Our reference: ECM Ref: 9822625
Contact: Kathryn Saunders
Telephone: (02) 4732 8567

1 December 2021

**Request for Advice – Oakdale West Estate MOD 9 – Amendment to
Approved Concept Plan and Increase of Building Height for Building 2C
SSD-7348-Mod-9**

Figure 7: Warehouse 2C Elevations (Source: SBA Architects)

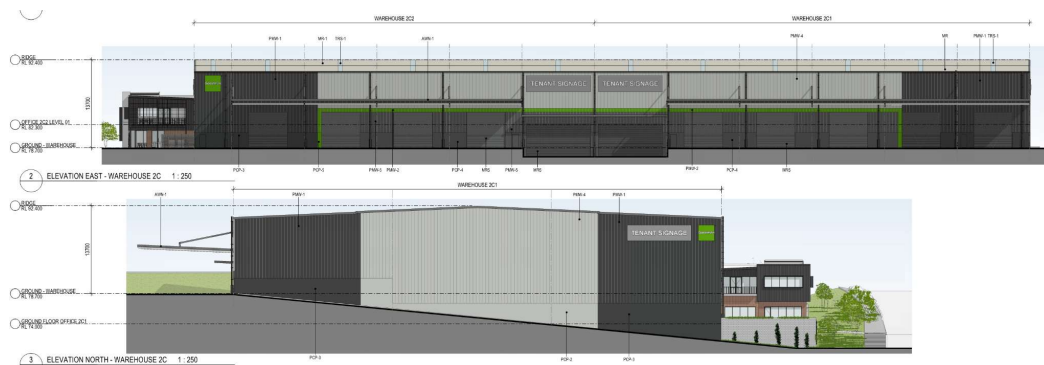
DPIE notes that the proposed effective height of Building 2C is approximately 22.2m, which exceeds the 15m height control provided by Part E6 Erskine Business Park of the Penrith Development Control Plan 2014, which applies to the site.

Whilst there are no major objections to the height increase, however it is raised for strong consideration, that buildings 2C and 2D are exceeding the expected maximum heights anticipated by the DCP, whilst at the same time, amendments are sought to the layouts for these buildings which increase hardstand areas within the frontage of the site.

In addition, DPIE should seek to clarify the definition of height under SSD 7348, (i.e., effective height – being height above finished levels, or height above natural ground level).

Attachment 1 – Updated Site Masterplan

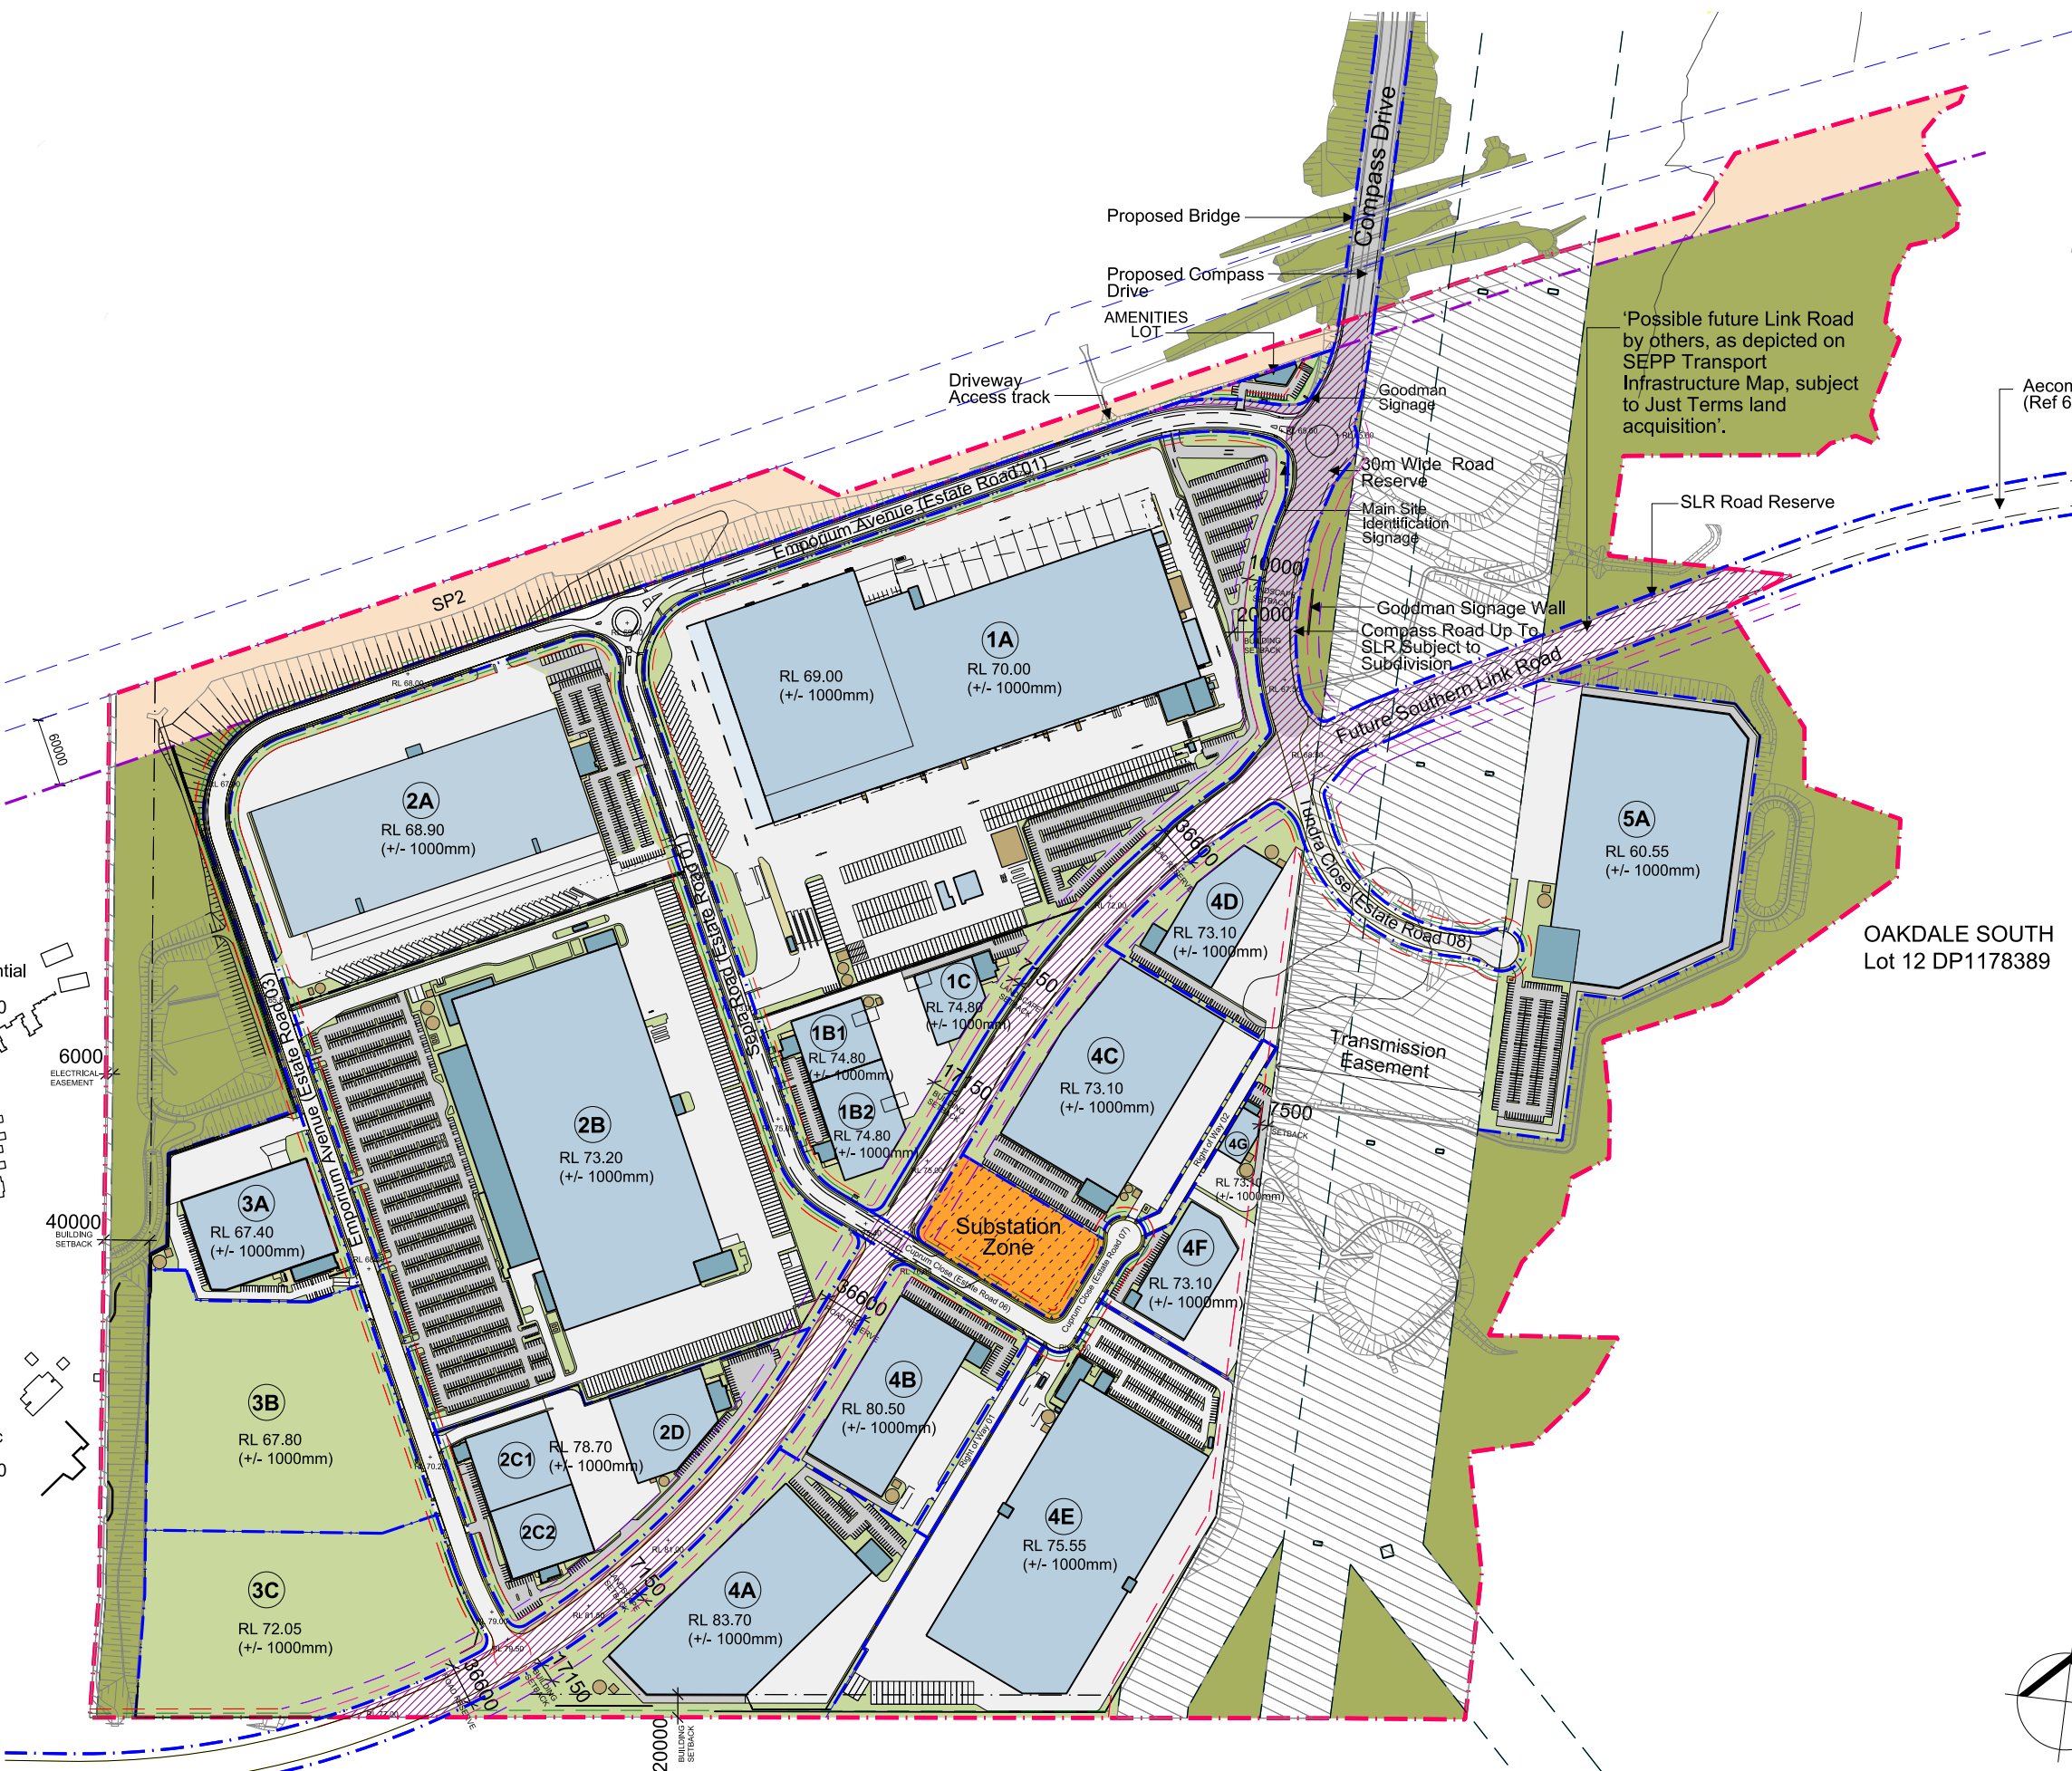
The net effect will likely result in poor streetscape outcomes such as bulk and overbearing impacts, owing to high retaining walls and/or narrow steeply battered frontages, coupled with ineffectual landscaping.

Council's previously issued comments in correspondence dated 12 and 18 November 2021, in relation to SSD-979468 remain relevant and are to be considered, particularly those provided in relation to the new access road and carparking areas now proposed within the front setback of building 2C and 3D to Southern Link Road.
